City of Albuquerque

RE: CONC GRADING & DRAINAGE PLAN FOR GOODWILL INDUSTRIES (D-13/D7)
RECEIVED OCTOBER 21, 1994 FOR S DEV PLAN FOR BLDG PRMT APPROVAL
ENGINEER'S STAMP DATED 10-19-94

John P. Curtin, P.E.
Civil Engineer/Hydrology

GRADING AND DRAINAGE PLAN

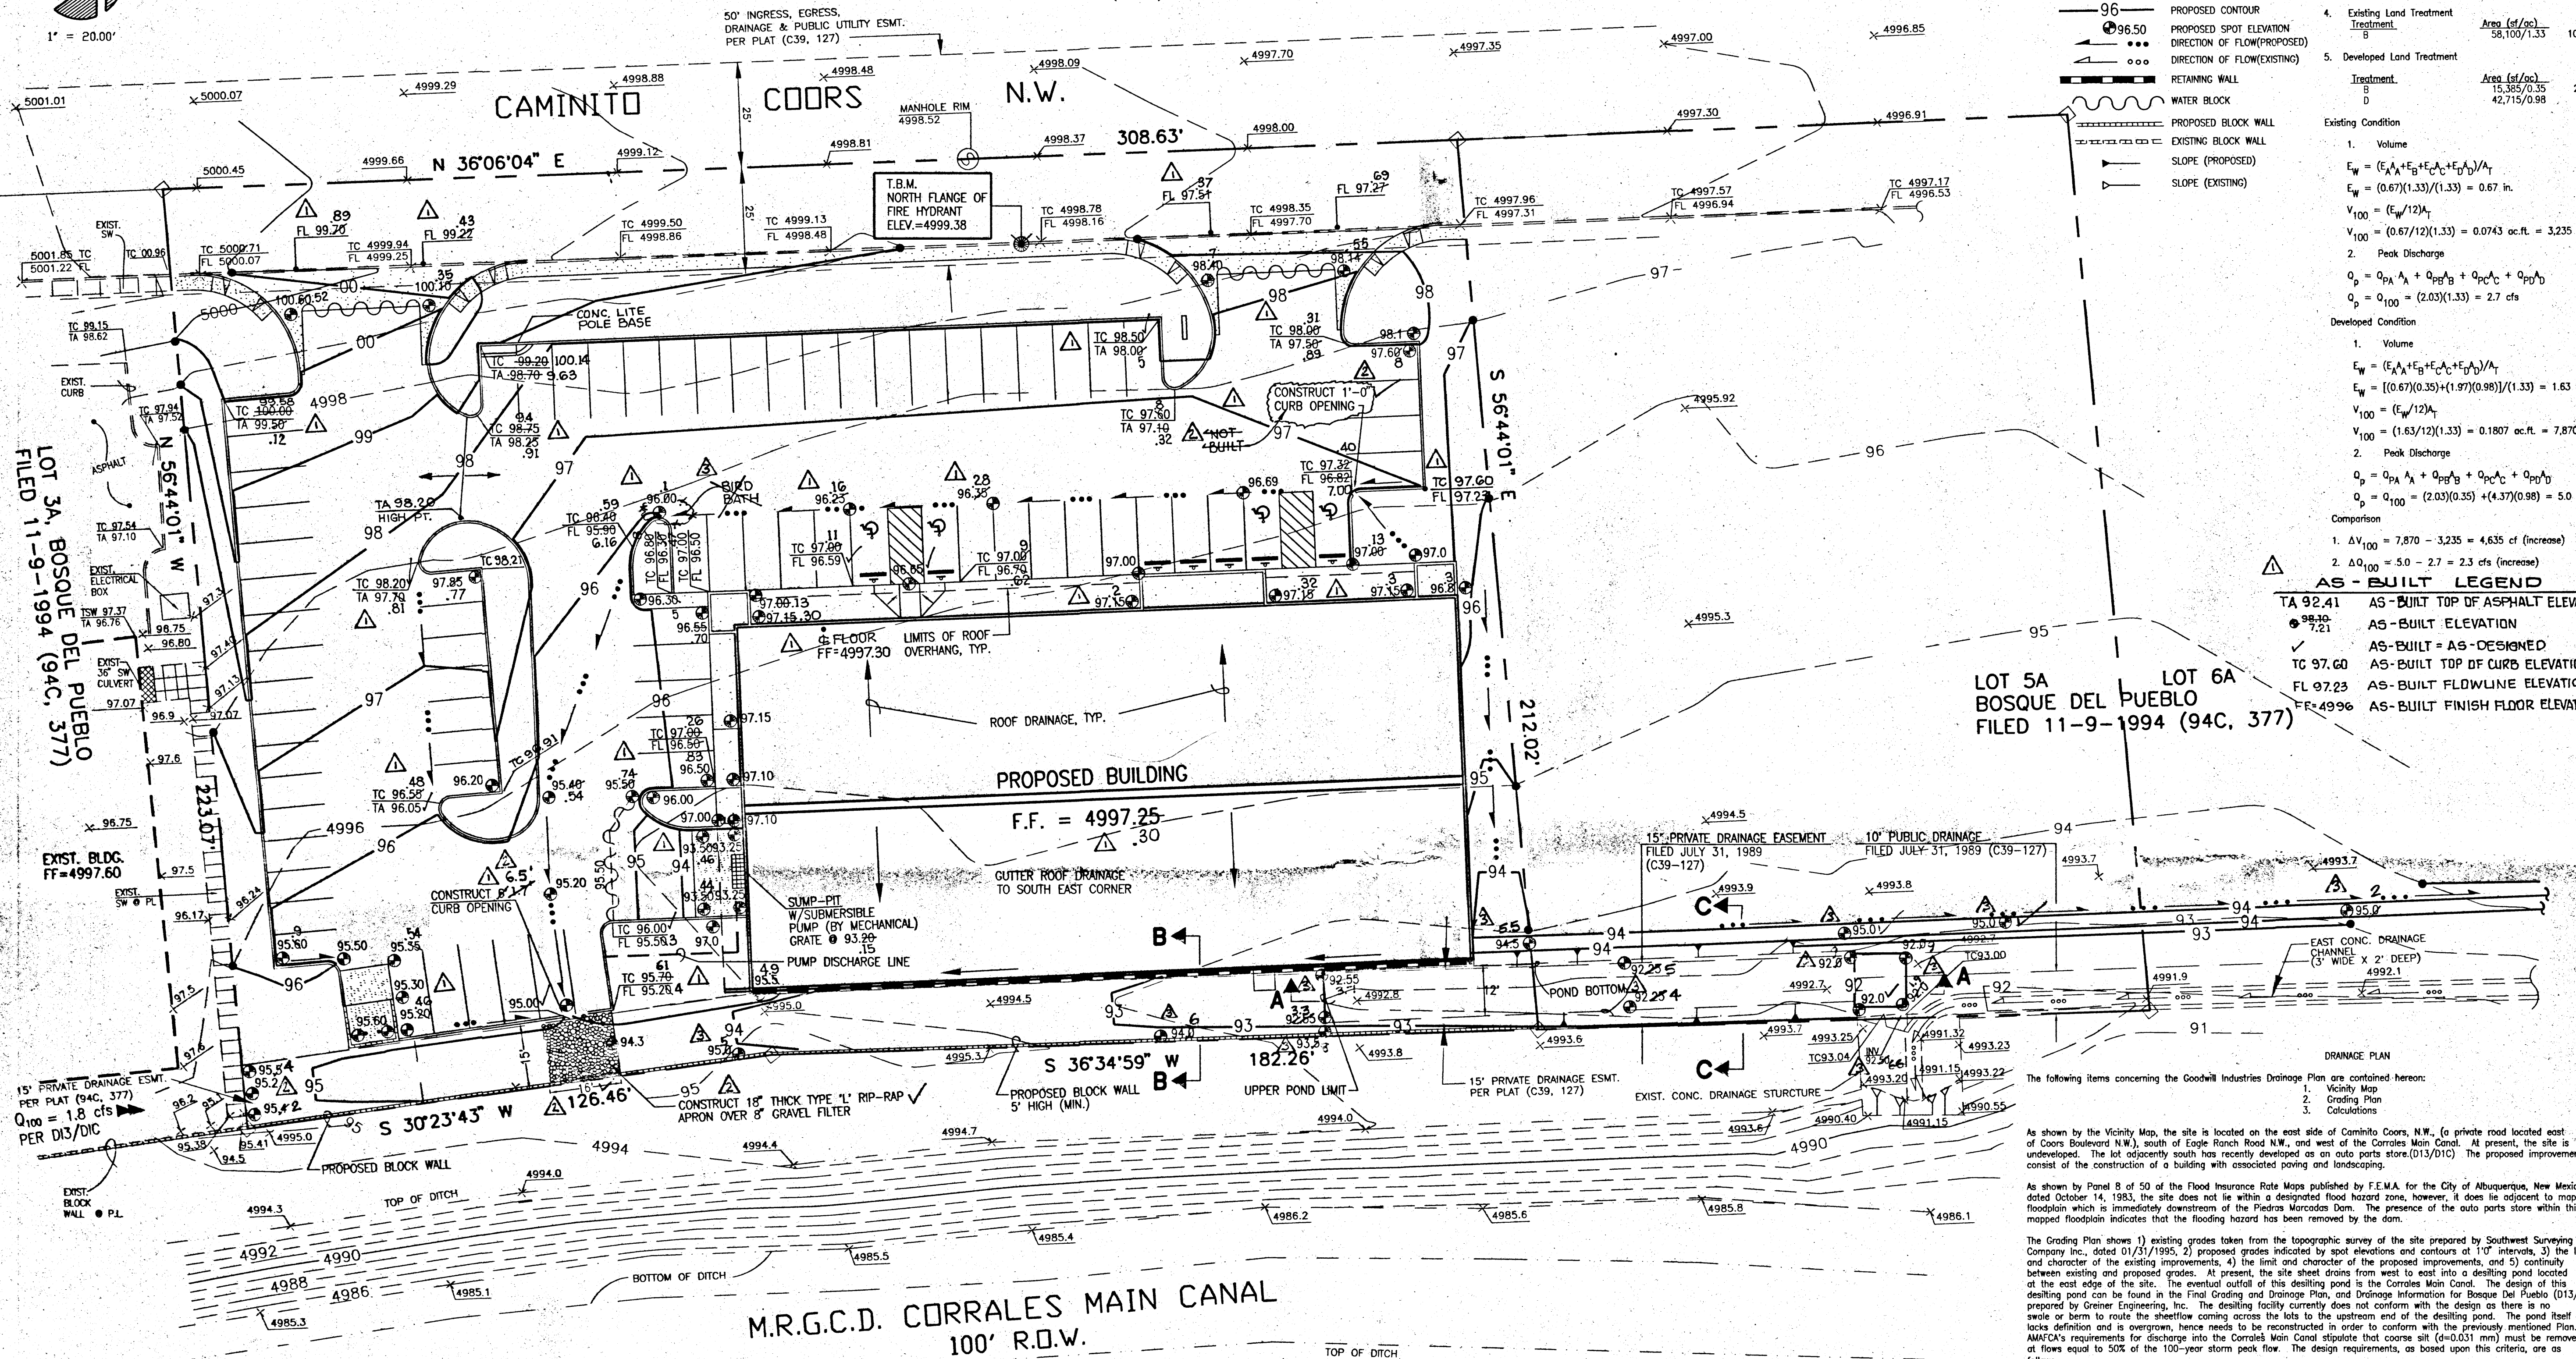
1. Existing contours or spot elevations must extend at least 25' beyond the property boundary. Indicate what the grading is along the Corrales Main Canal beside the site.
2. Label the desilting pond on the Plan and indicate the maximum water surface elevation. Provide calculations to verify that the required volume has been provided to make up for the encroachment.
3. Show the off-site flow location on the Plan. Indicate the small bar ditch at the south perimeter which accepts this flow.
4. What is the existing curb height on Caminto Coors? What is the proposed curb height in the parking lot? Provide Top of Curb elevations for these areas.
